Our Ref: R/2025/21  
File No: 2025/703352

**Request for Advice - Exhibition of [SSD-80441462 Waterloo Mixed Use Development 881-885 Bourke Street](#)**

Thank you for your correspondence dated 12 November 2025 inviting the City of Sydney (the City) to comment on the exhibition of the main works application for the mixed-use development at 881-885 Bourke Street Waterloo.

1 Warehouse Danks Street

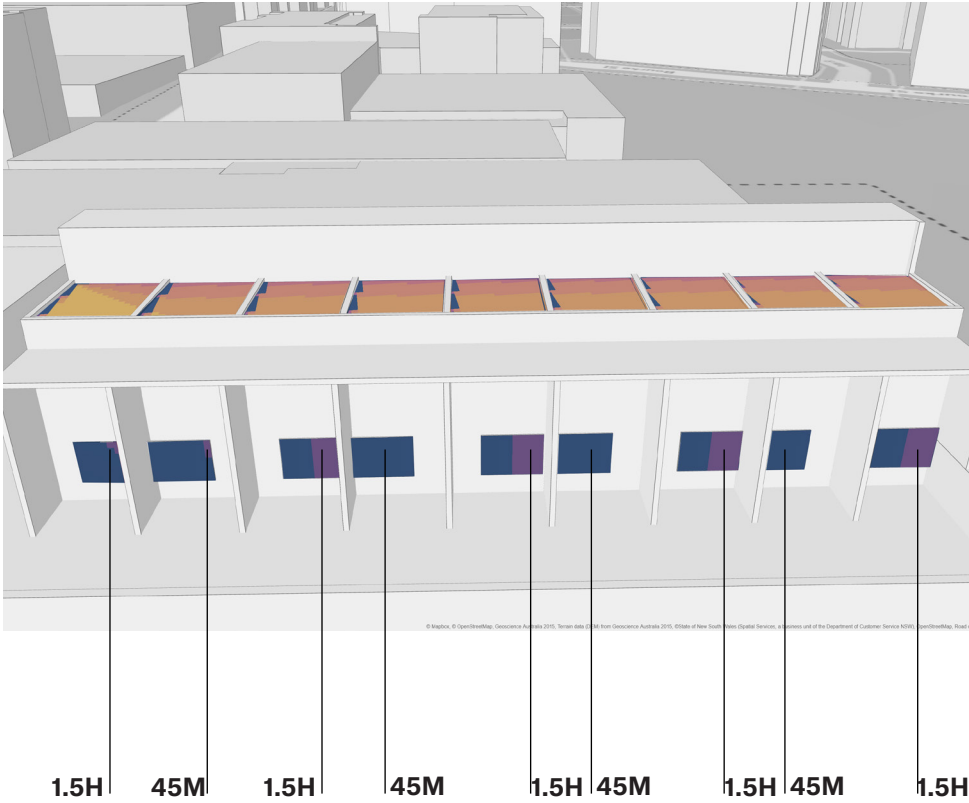
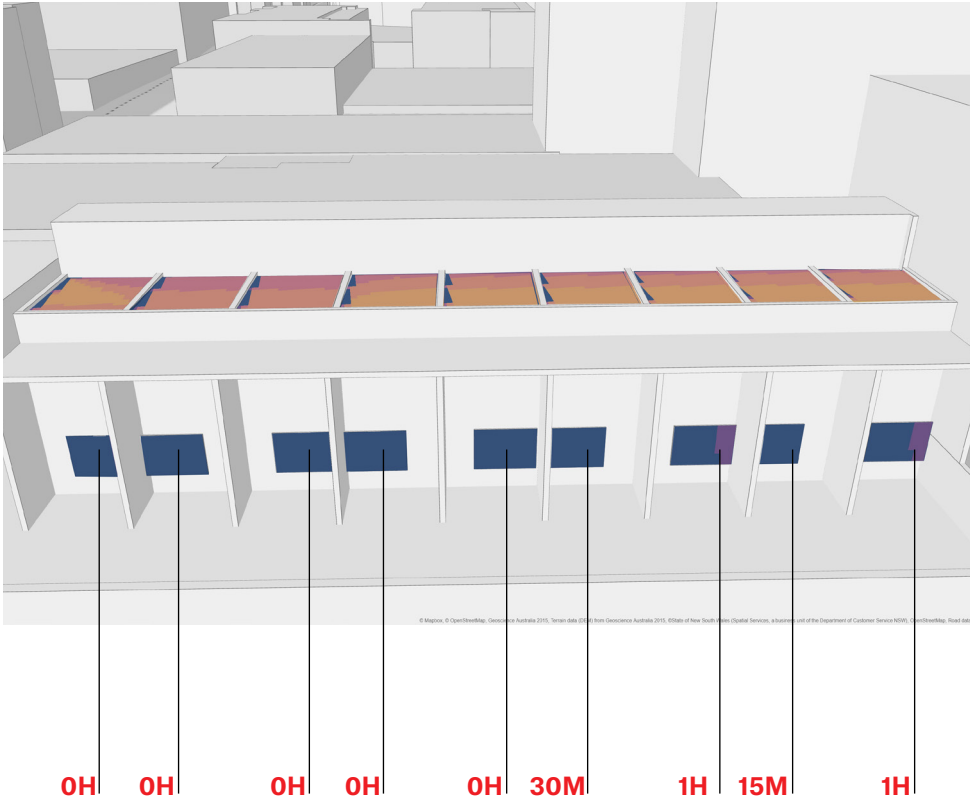
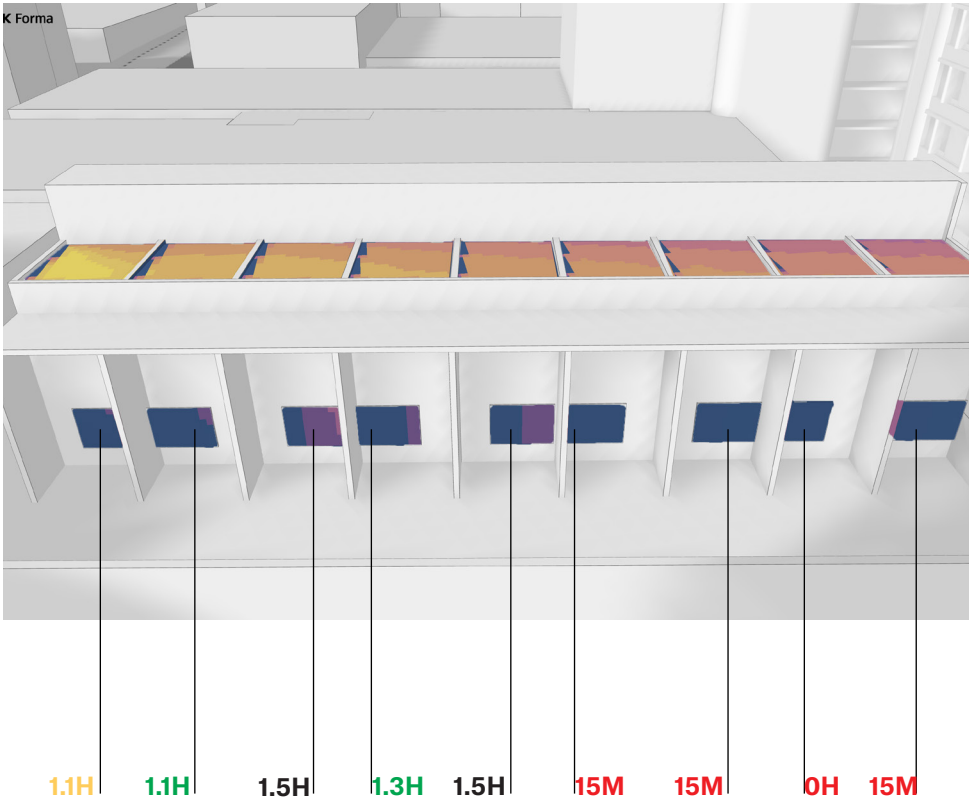
- Existing condition is that 84% (11 units) receive 2 hours solar access and 100% (13 units) receive some sun.
- D/2020/45 concept approval Condition 83 required amendments to the building mass so that at least 9 units (70%) achieve 2 hours solar access.
- The proposed envelopes and massing at Parcel 1, adversely impact on solar access to this building. Overall building compliance of solar access has not been documented. At least 70% of units within the building should

be provided with at least 2 hours solar access as per Apartment Design Guide and the intention of Condition 83 in D/2020/45.

- iv. Demonstrate 2 hour solar access to 788-822 Bourke Street is not reduced below 52% (50 units), achieve 70% of units within 1 Danks Street, and the existing versus proposed solar access provision to 895-899 Bourke Street. Furthermore, the DASC0 precinct as approved by D/2021/1415 (as modified) achieves 67% (236 of 351 units) solar access. The proposed development will further reduce solar access on this precinct and the submitted documentation in Appendix "E3 Architectural Design Report A2 Solar Access" has not accurately assessed the extent of solar access and impacts.

Typical Plan

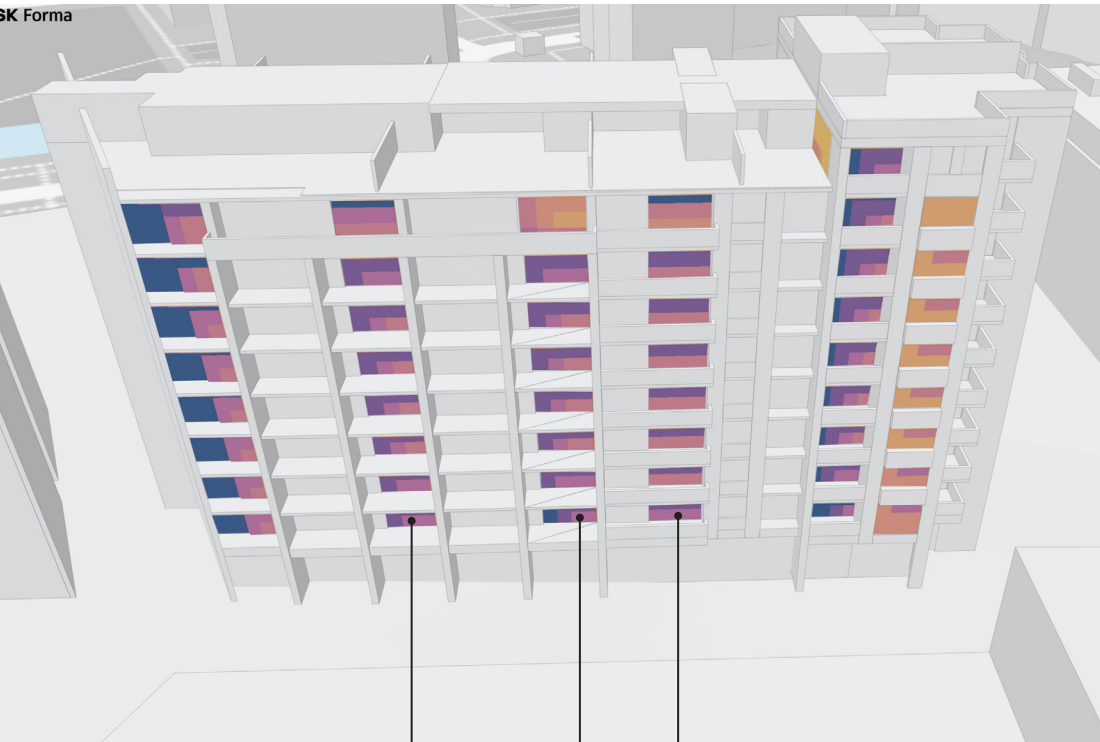
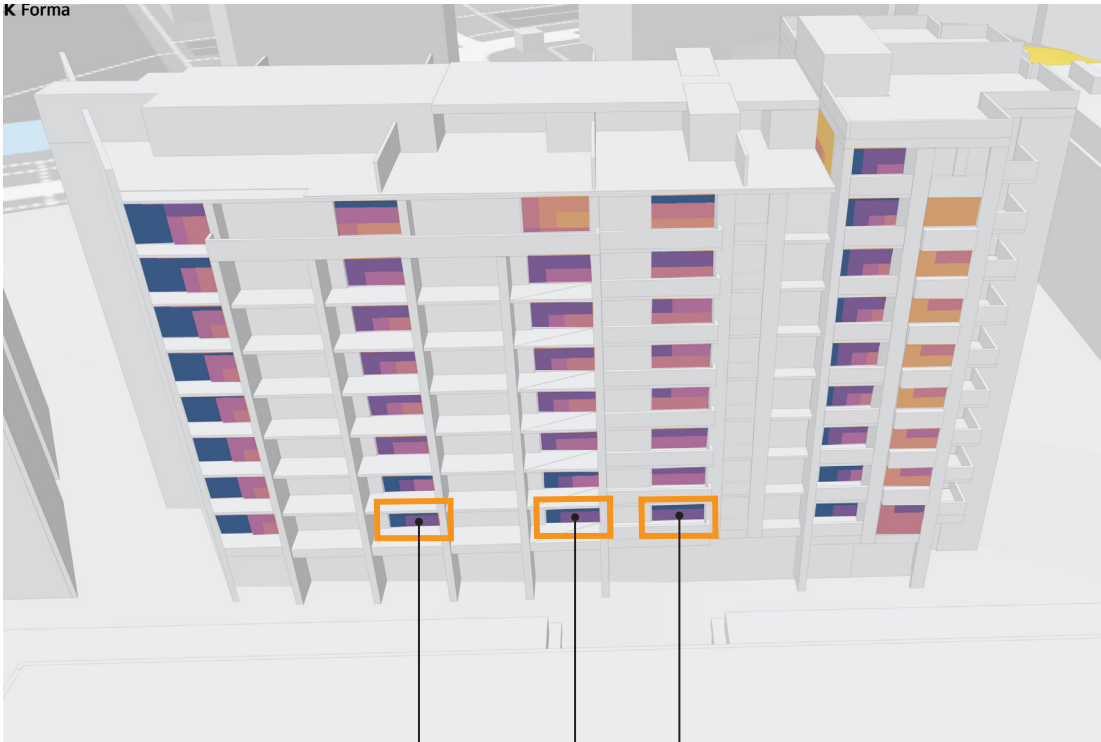
- Existing condition is that 52% (50 units) receive 2 hours solar access and 42% (41 units) receive no direct sun.
- D/2020/45 concept approval Condition 83 and 87 required amendments to the building mass so that no less than 52% (50 units) received 2 hours solar access.
- The proposed increased envelopes and massing at Parcel 2, further reduces the number of units that receive 2 hours solar access to 48% (47 units). This is inconsistent with the City’s [“Minimising Overshadowing of Neighbouring Apartments Documentation Guide”](#), as where there are less than 70% of units achieving 2 hours solar access, there is to be no further decrease, and the 20% reduction in time does not apply to the Ground Level units as they currently receive 2 hours solar access.

DEEP SOIL ZONES			
	Site Area	Deep Soil	%
STAGE 1	8386sqm	1425sqm	17%
STAGE 2	6135sqm	752sqm	12%
TOTAL	14521sqm	2177sqm	15%

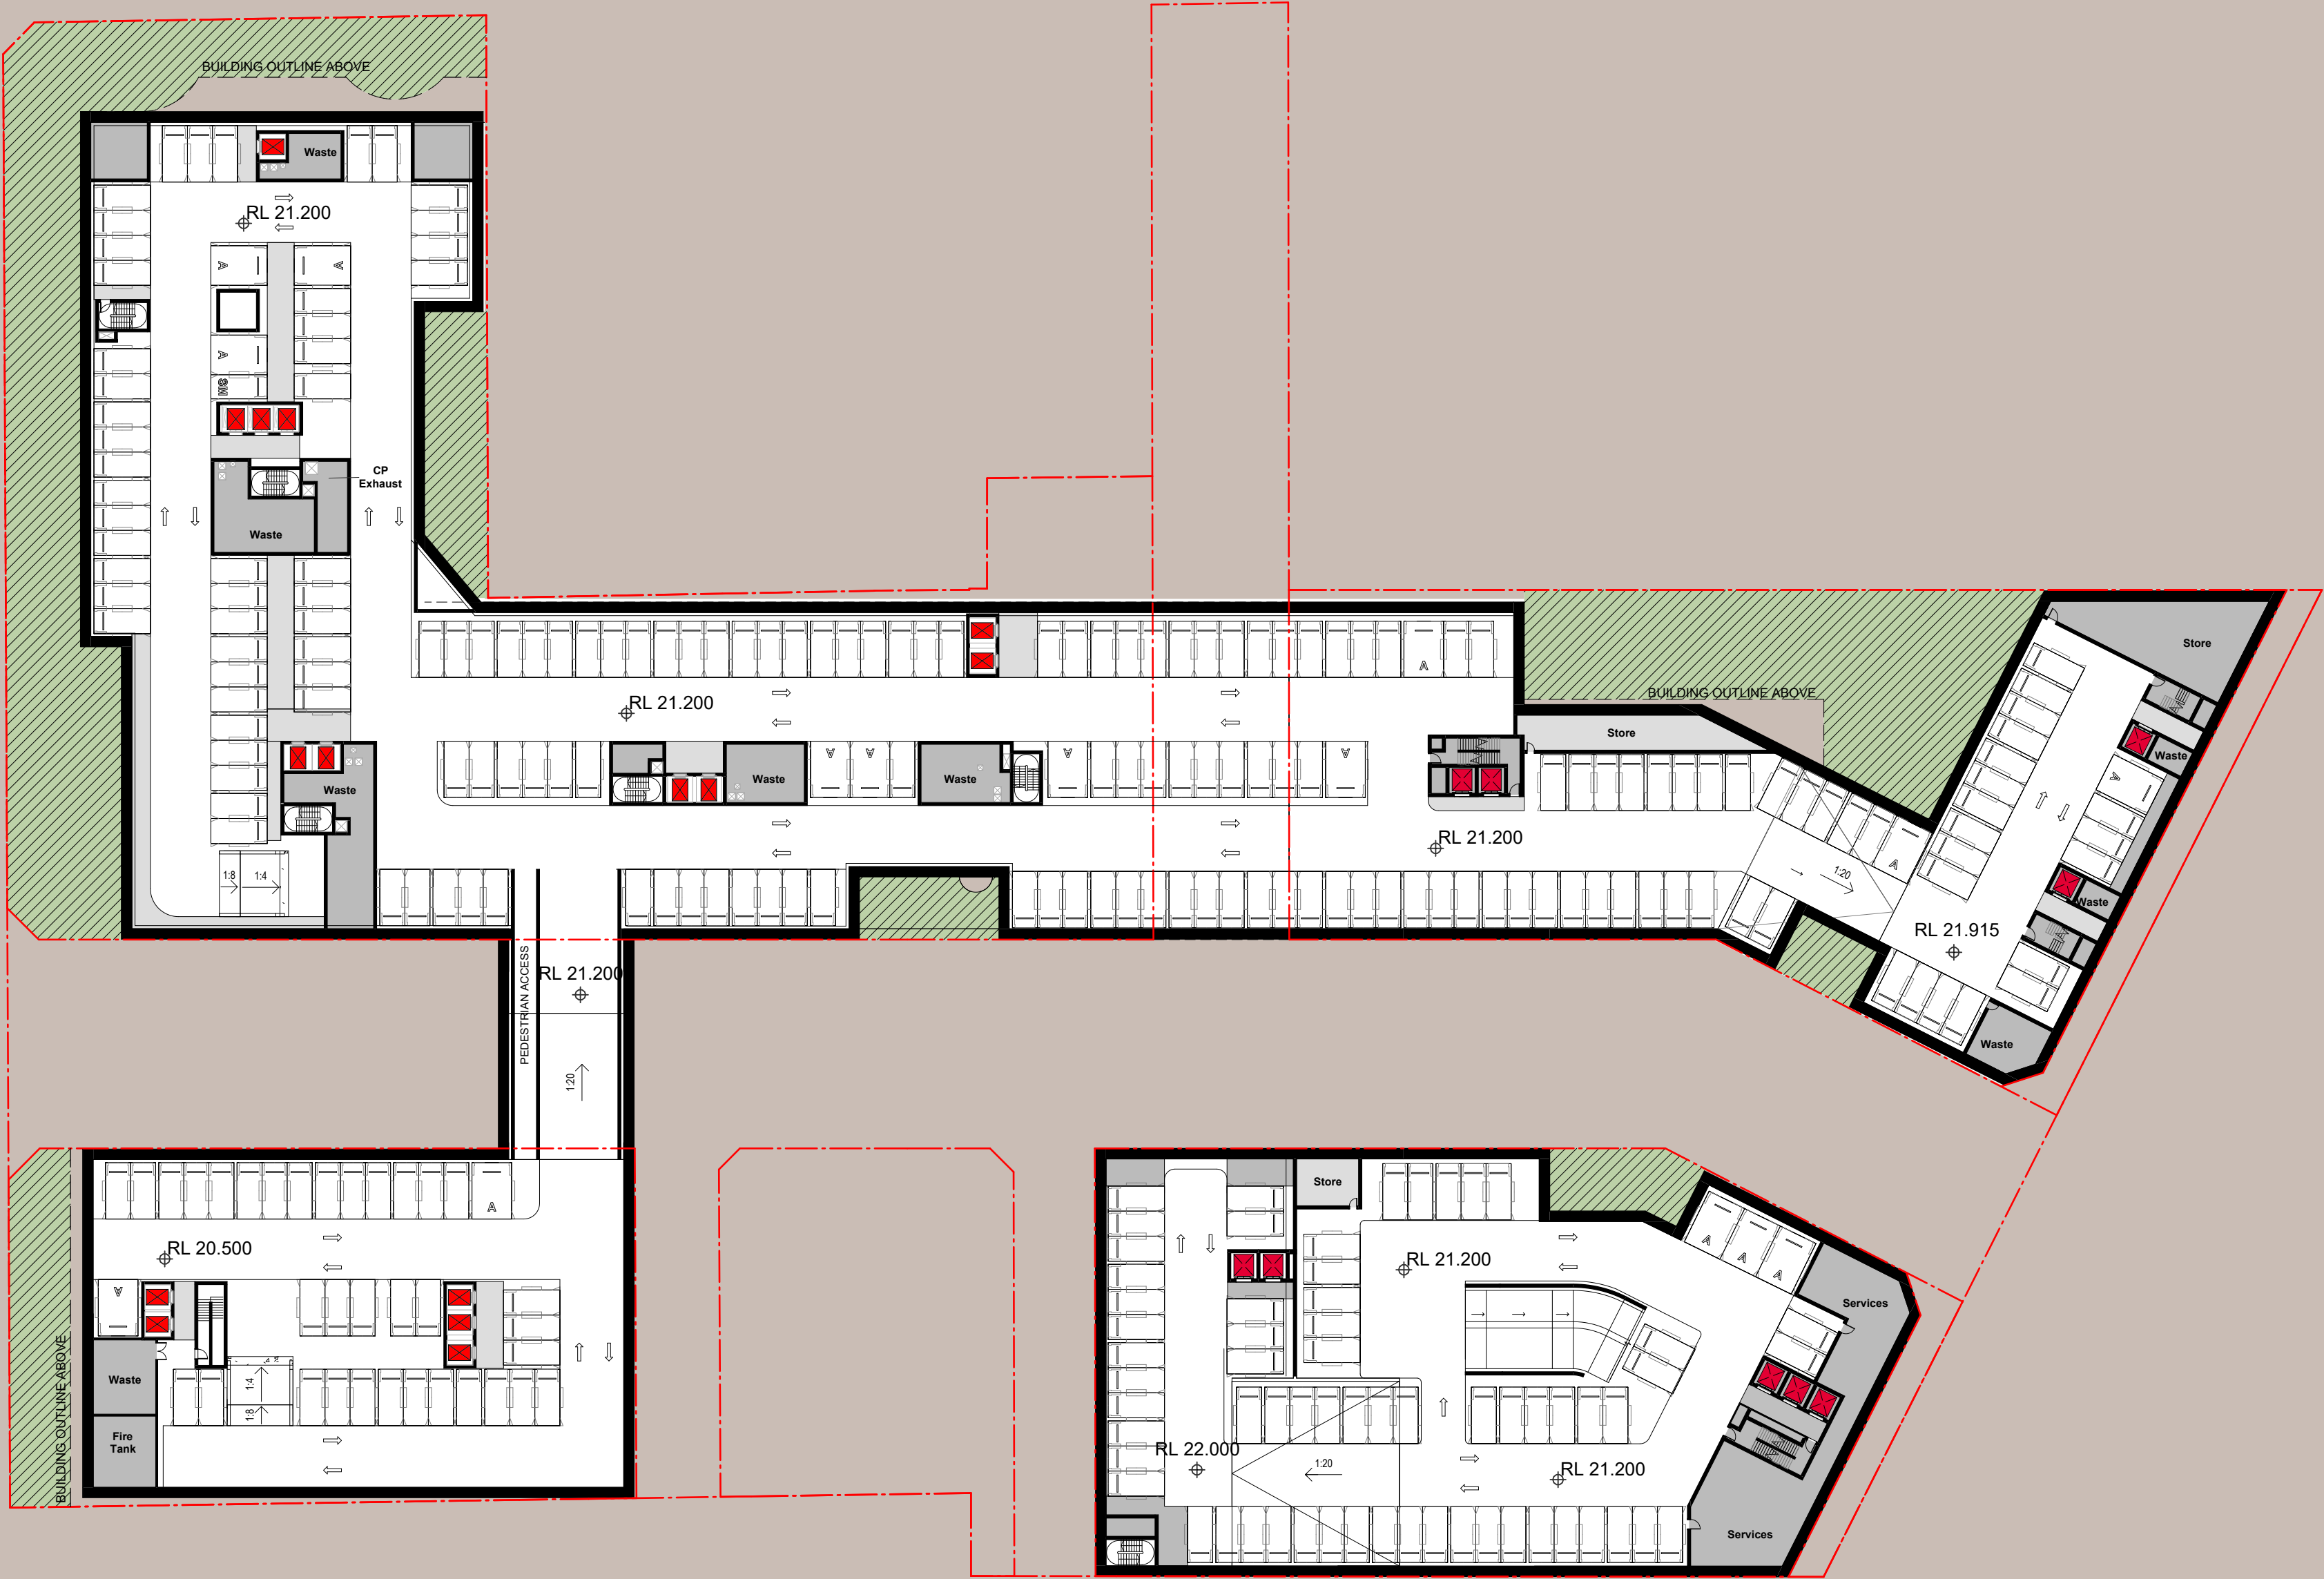
- ii. The basement envelope extent should be reduced to allow for an improved and better rationalise deep soil allocation across the precinct.
- iii. Parcel 2 only achieves 8% deep soil (258m<sup>2</sup>), not the 20% (666m<sup>2</sup>) that is described within the Appendix E1 Design Report.

- iv. Parcel 3 only achieves approximately 2% deep soil (80m<sup>2</sup>). It is recommended that the basement level envelope is pulled in from the southern boundary to allow for deep soil planting between this Parcel 3 and 895-899 Bourke Street.
